East Anglia ONE North and East Anglia TWO Offshore Windfarms

Applicants' Responses to Examining Authority's Written Questions

Volume 5 – 1.3 Compulsory Acquisition, Temporary Possession and Other Land or Rights Considerations

Date: 2nd November 2020

| Important Hedgerows and Tree Preservation Order Plan Sheet Number: Sheet 2 of 12 | | | Rev | 5 | British National Grid OSGB36 |

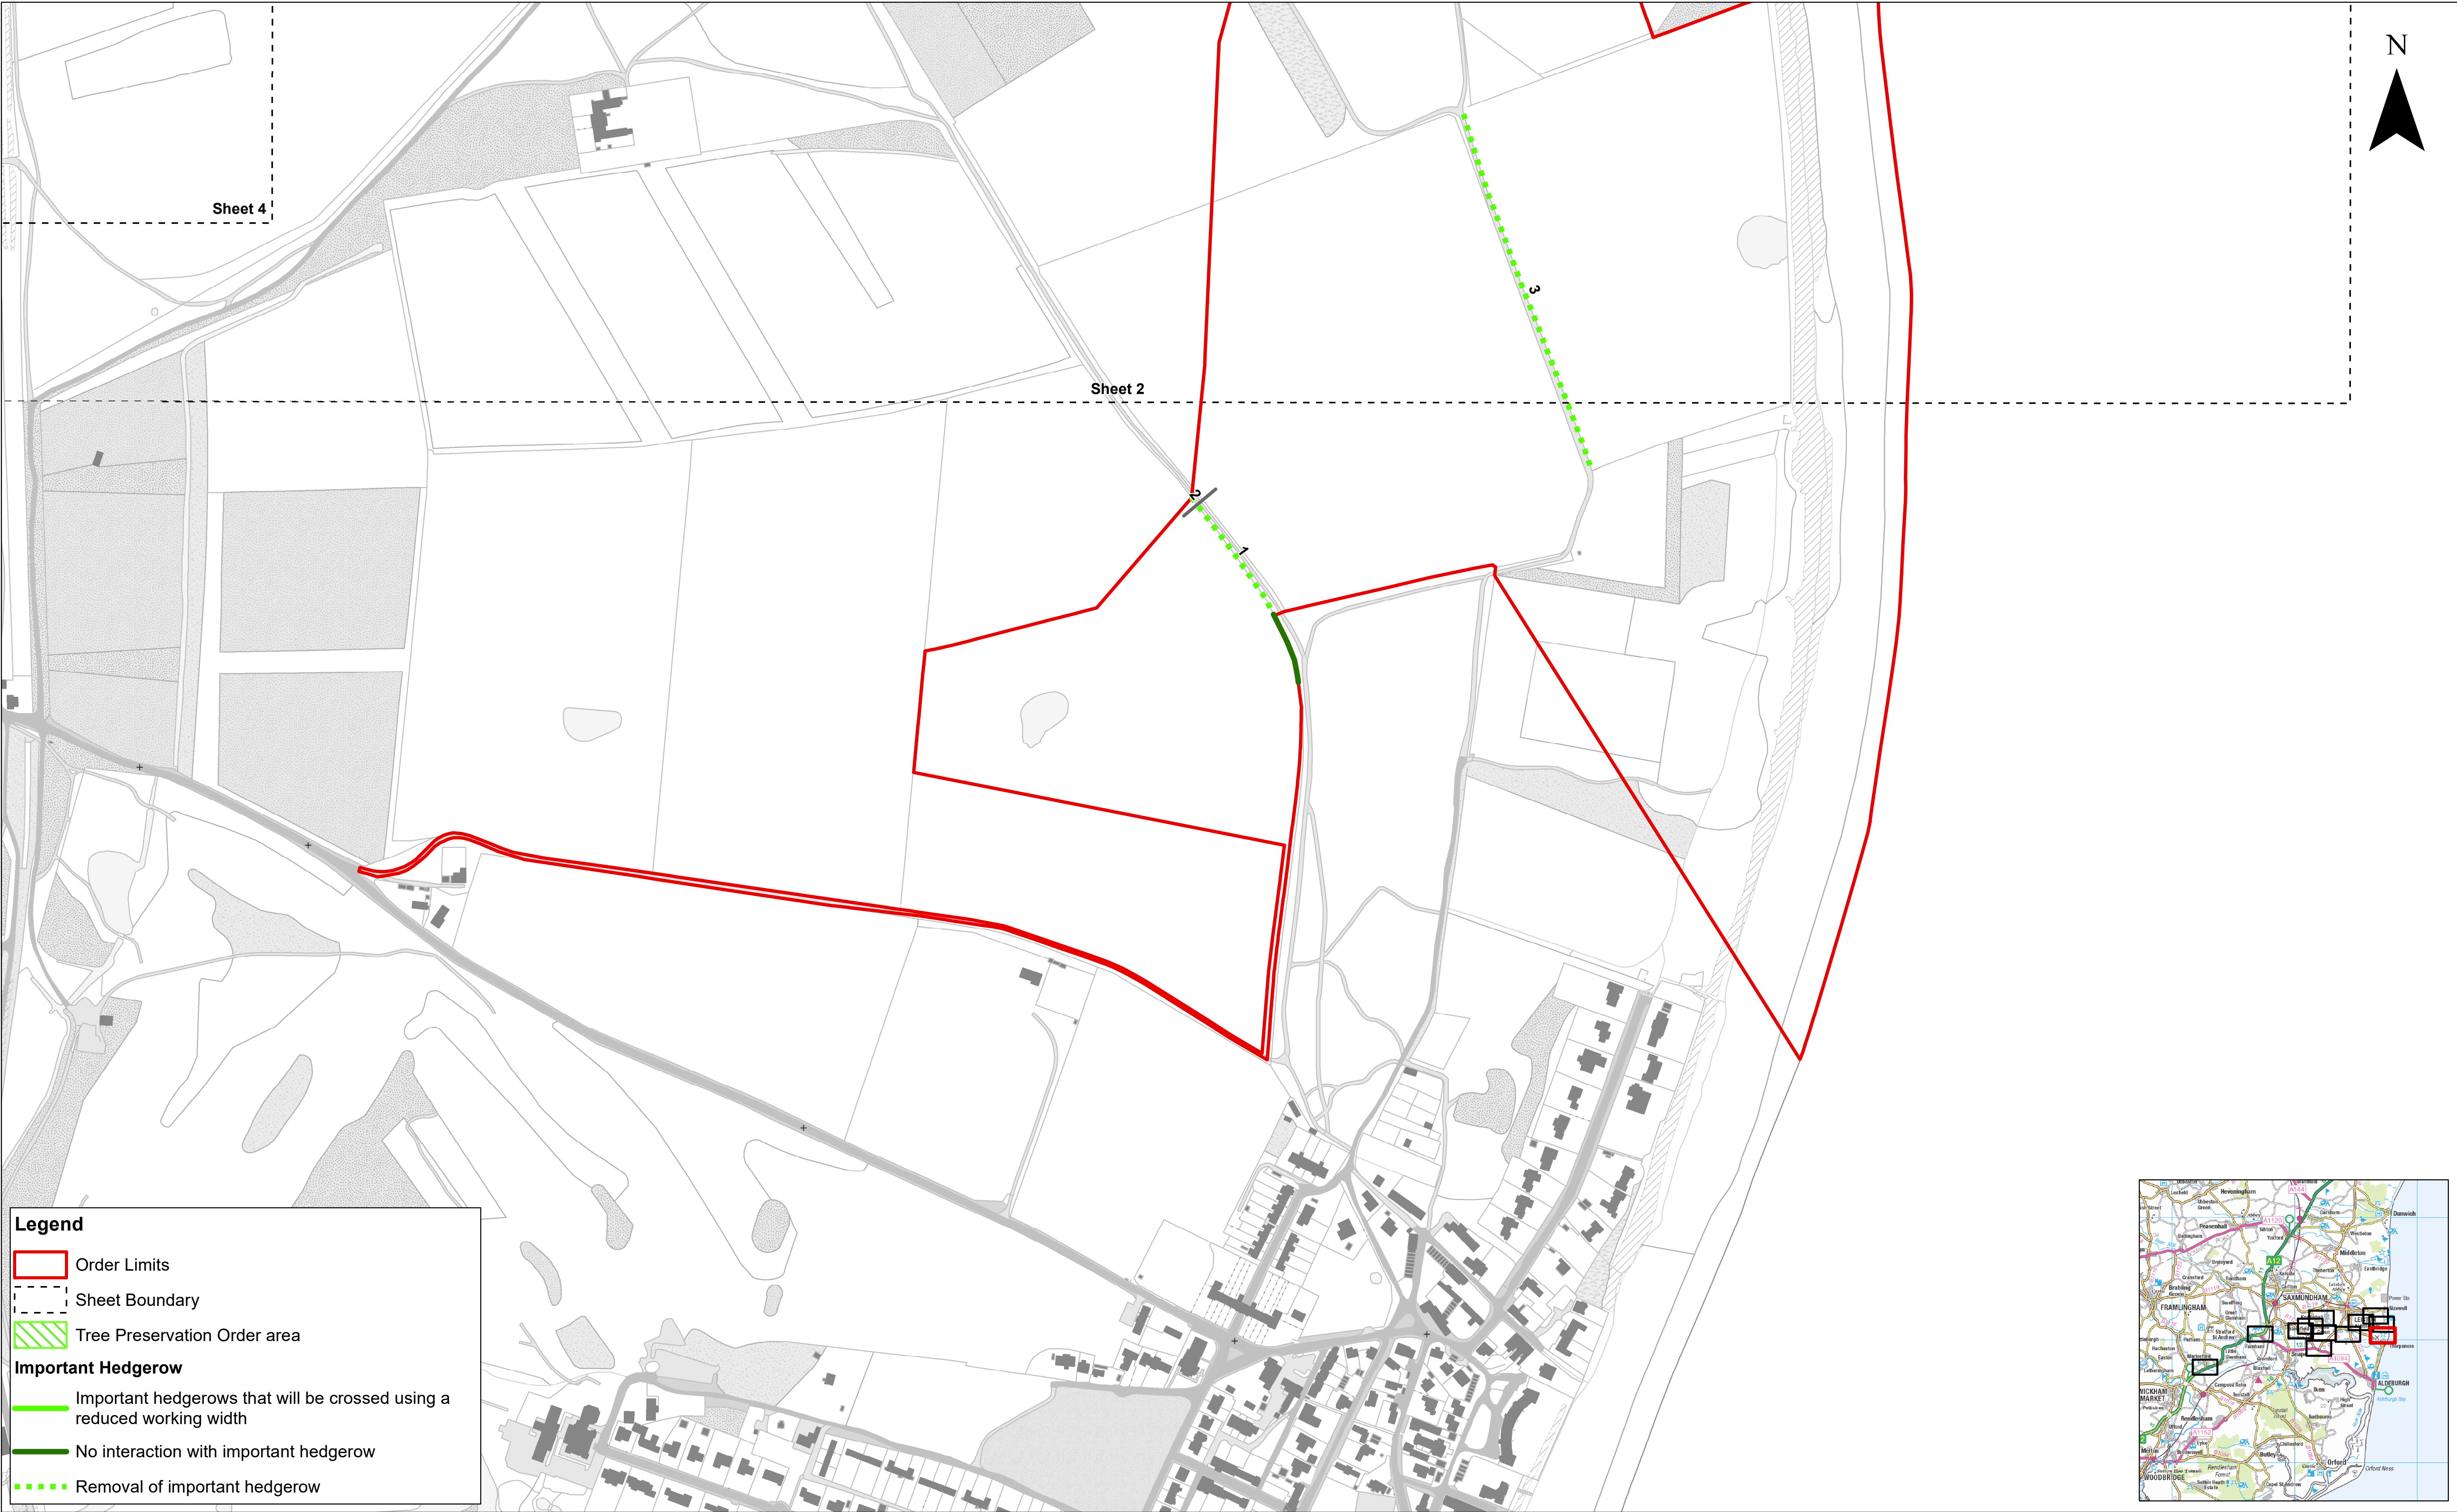
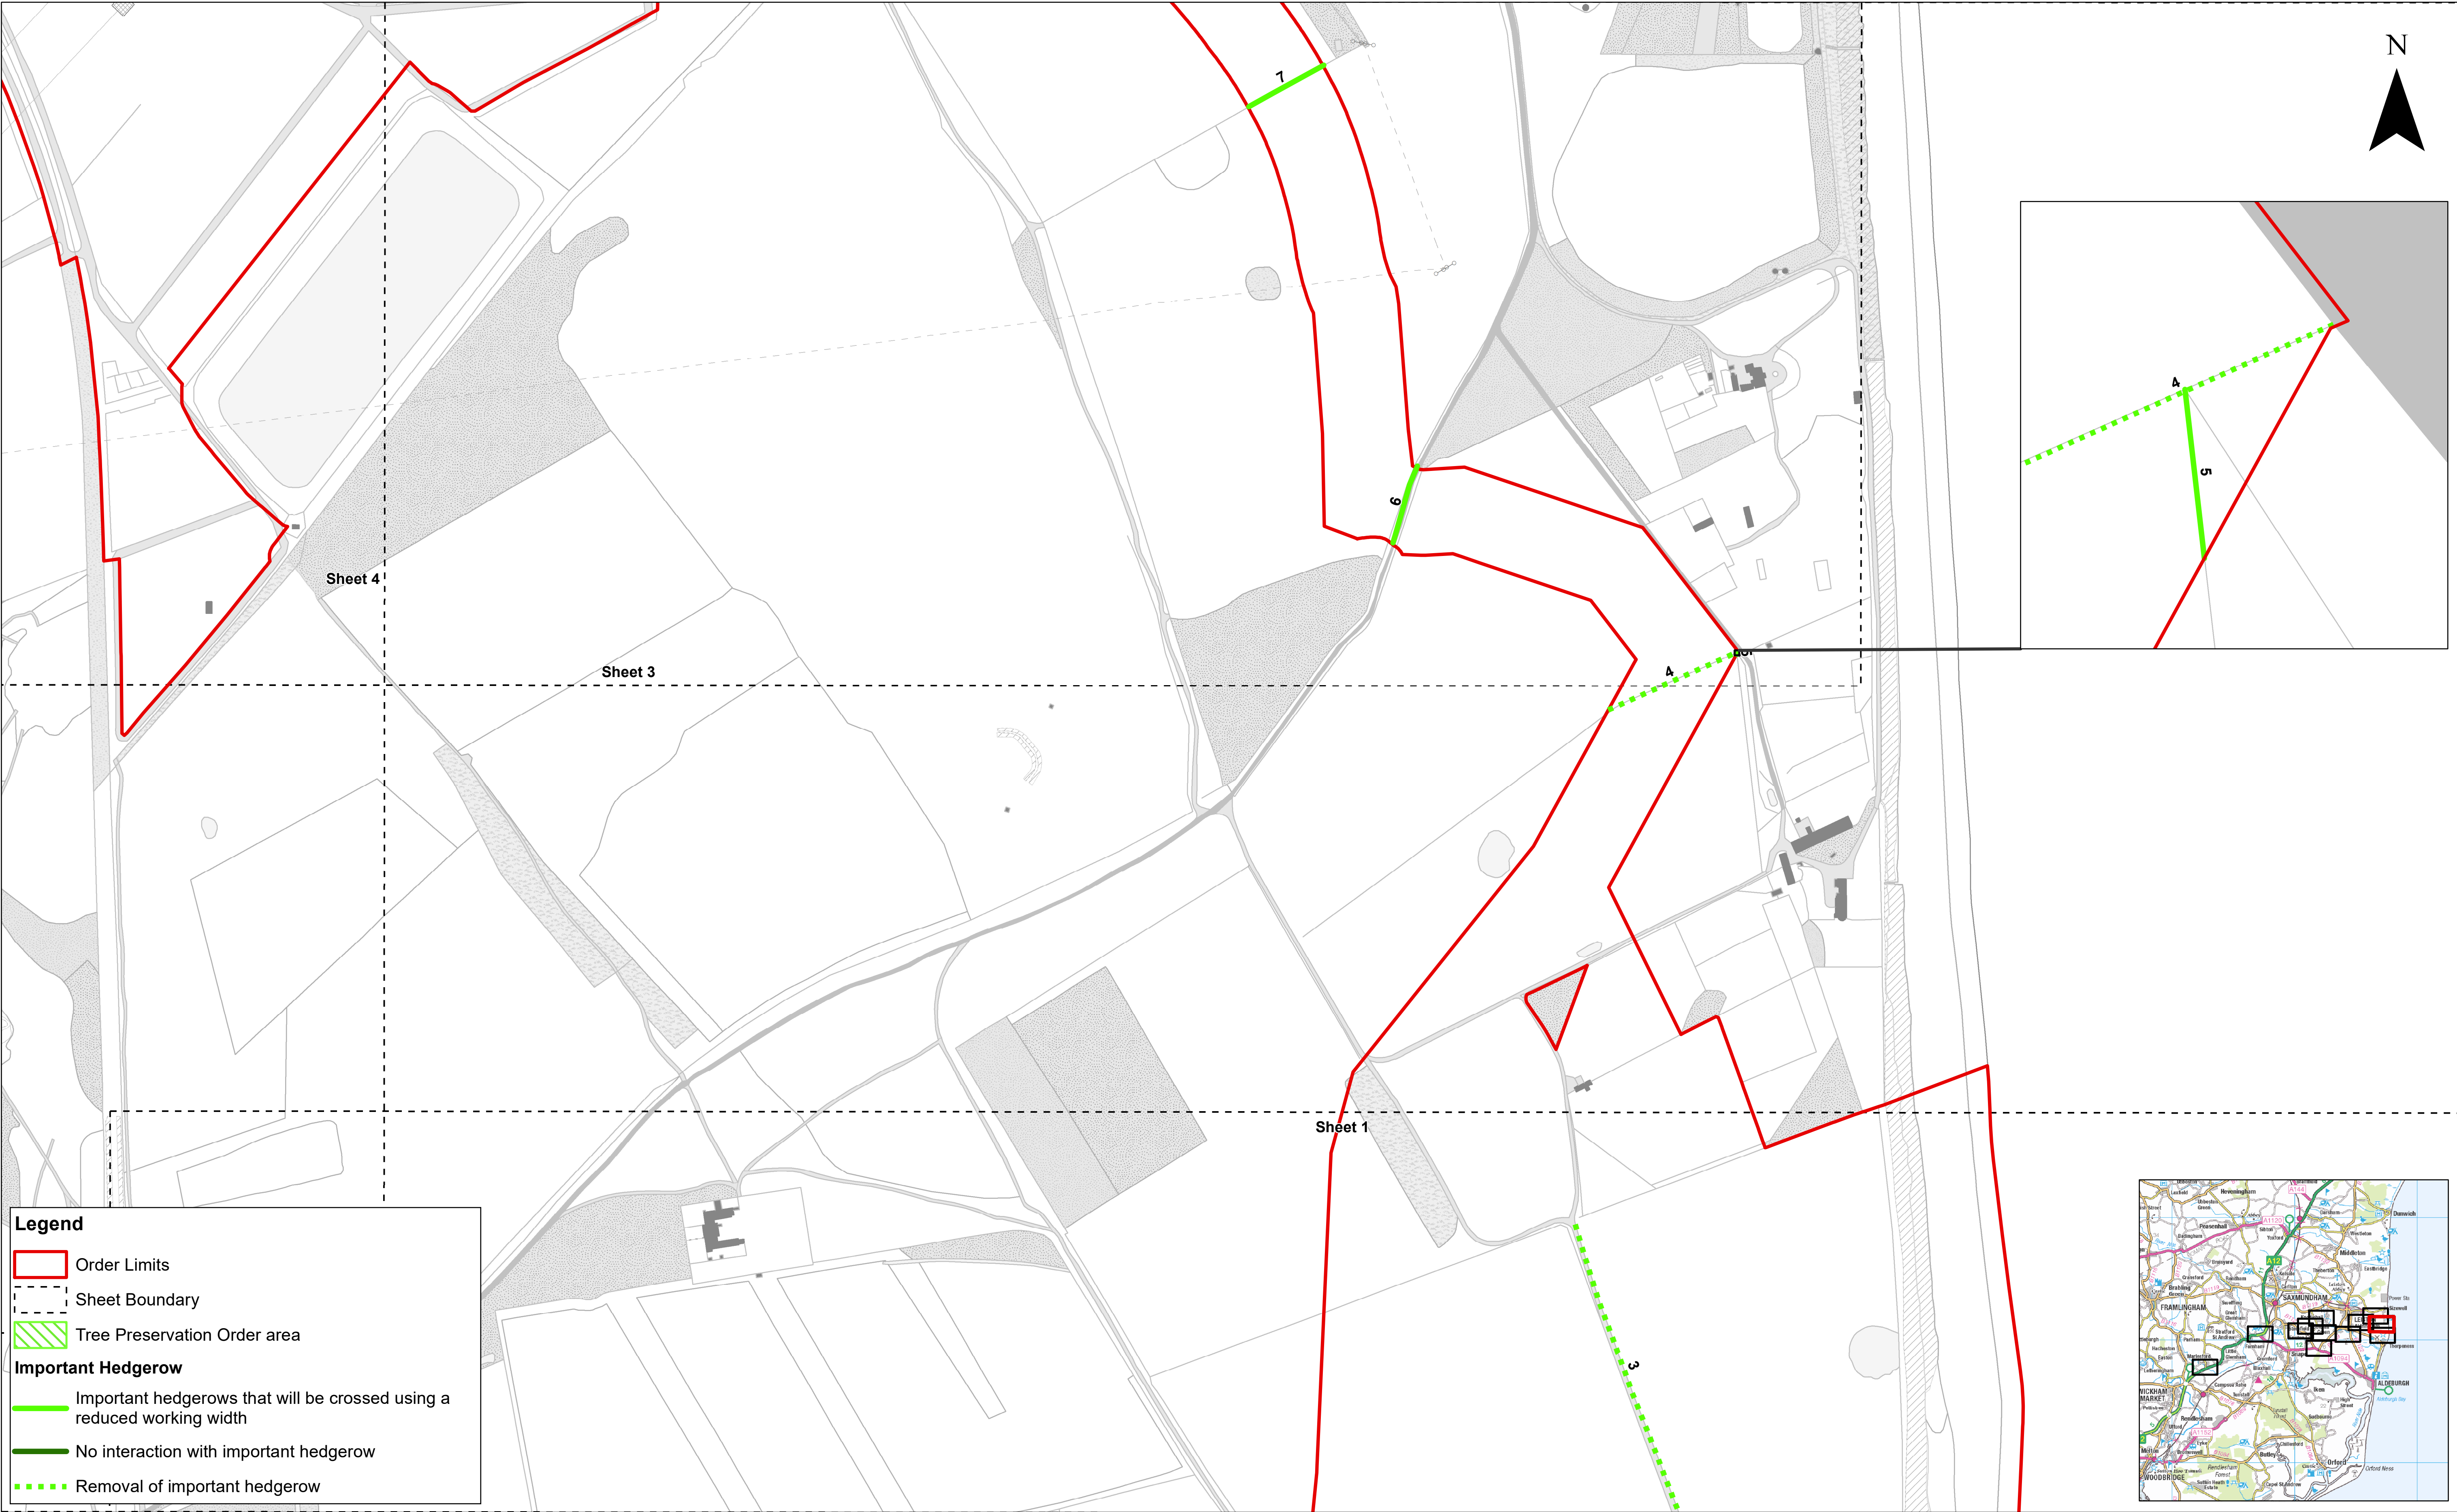
1.3.34	The Applicant	<p>1 2</p> <p>Schedule 11 part 2 lists important hedgerows that will be crossed using a reduced working width with reference to the important hedgerows and tree preservation order plan [APP-020].</p> <p>Please include in the crossing schedule and plan requested</p>	<p>This information is included in the Onshore Crossing Schedule which can be found in Appendix 7 of this document.</p>

ExA. Question Ref.	Question addressed to	ExA. Question	Applicants' Response
		elsewhere in this question set details of important hedgerows crossed, specifying the necessary width and the crossing method to be used in each case.
